# INDEPENDENT AIR QUALITY REVIEW WESTCONNEX – M4-M5 LINK

NSW Department of Planning & Environment

28 February 2018

# Independent Air Quality Review WestConnex – M4-M5 Link

TITLE
M4-M5 Link - Shadow diagrams and overshadowing
11.00 am analysis (21st June)
Iron Cove Link motorway operations complex (MOC4)
Rozelle

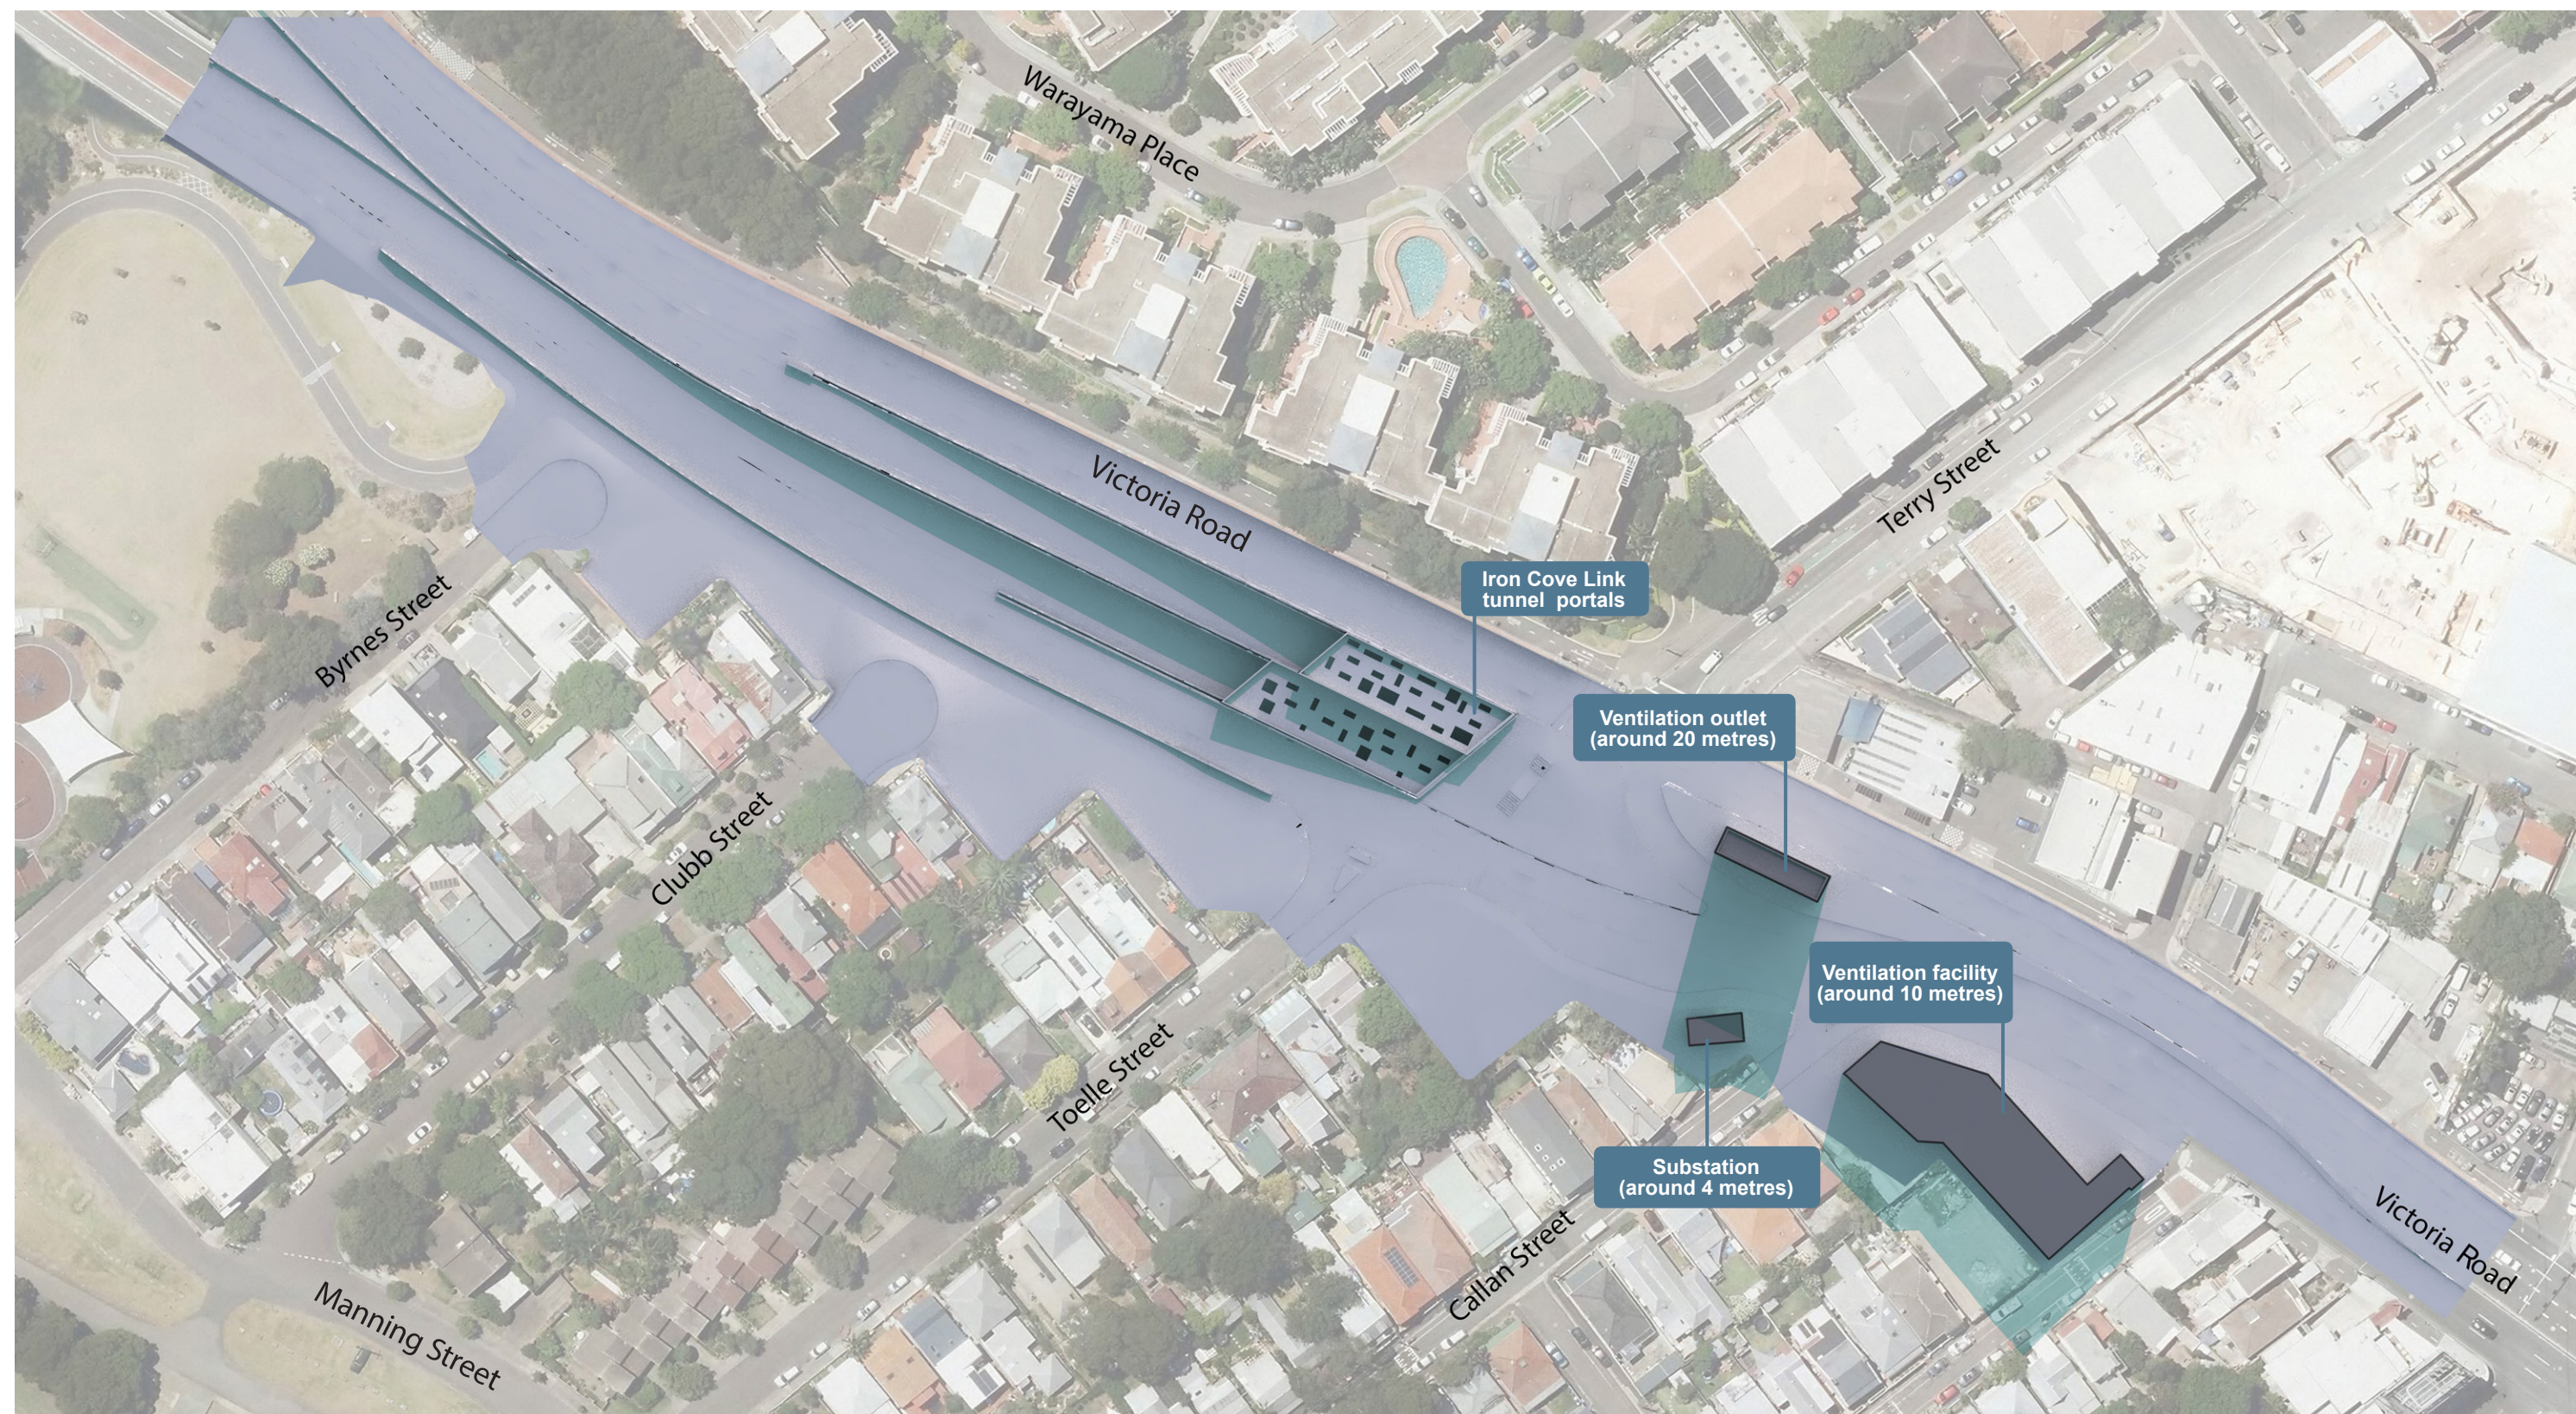
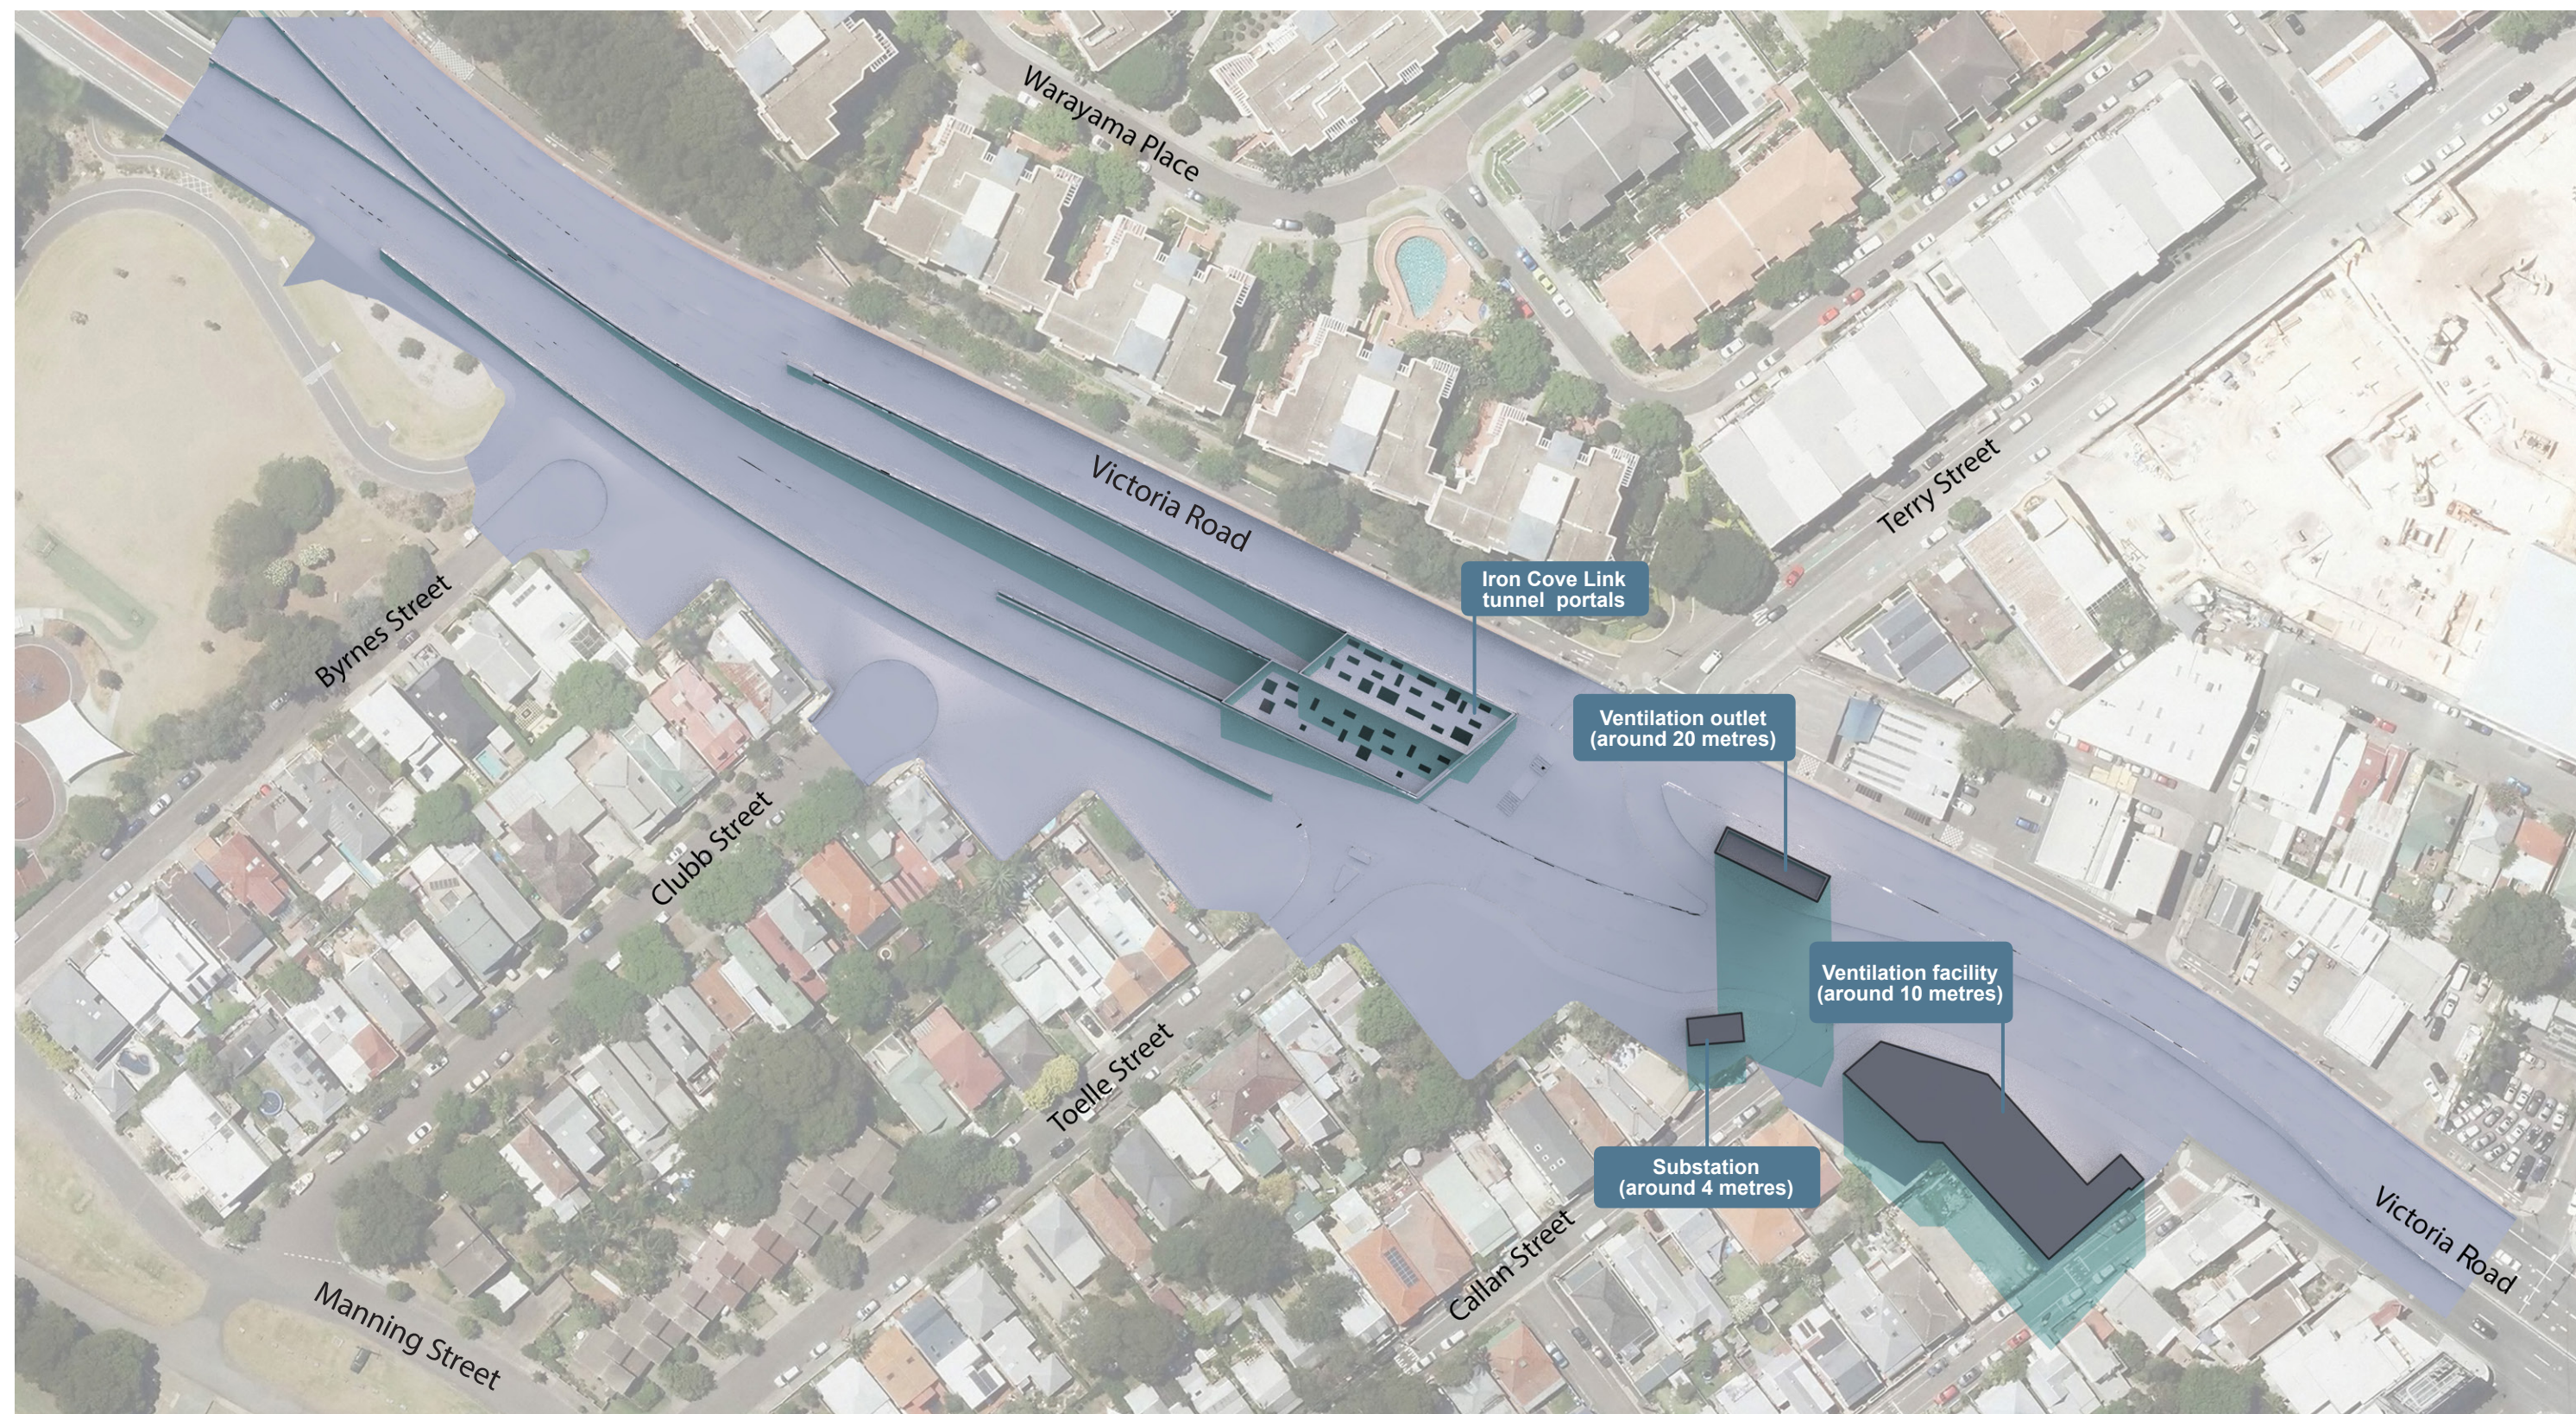
The air quality assessment comments *“there are only a small number of tall buildings in proximity to the proposed ventilation outlets, and therefore the effects of building downwash (refer to Annexure B) would probably have been rather limited”*.

The sensitivity test indicated that concentrations associated with the ventilation outlet on average increased by a factor of approximately 1.3. As the predicted impacts are low, it was determined that buildings effects are unlikely to represent a large source of uncertainty in the overall predictions.

Modelled concentrations for the Project effects on surface roads were predicted at two elevated receptor heights (10 metres (m) and 30m) for annual and 24-hour average PM<sub>2.5</sub>. The results indicate the influence of surface roads reduced at 10m and was negligible at 30m, and that near the ventilation outlets pollutant levels from the outlets were greater at 30m height than at 10m.
